Project Special Provisions
(Version 06.5)
Signals and Intelligent Transportation Systems

1. 2006 STANDARD SPECIFICATIONS FOR ROADS & STRUCTURES

The 2006 Standard Specifications are revised as follows:

LOOP WIRE TWISTING METHOD

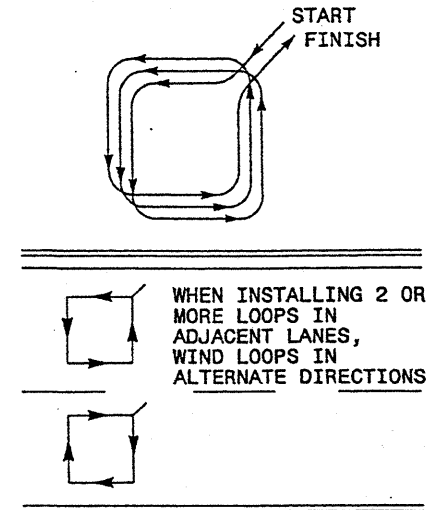
1.4. Inductive Detection Loops – Construction Methods (1725-3)

Page 17-20, Subarticle 1725-3, In the first paragraph on the page, revise the first sentence to:

“Twist loop conductor pairs a minimum of 5 turns per foot from where conductors leave saw slot to junction box.
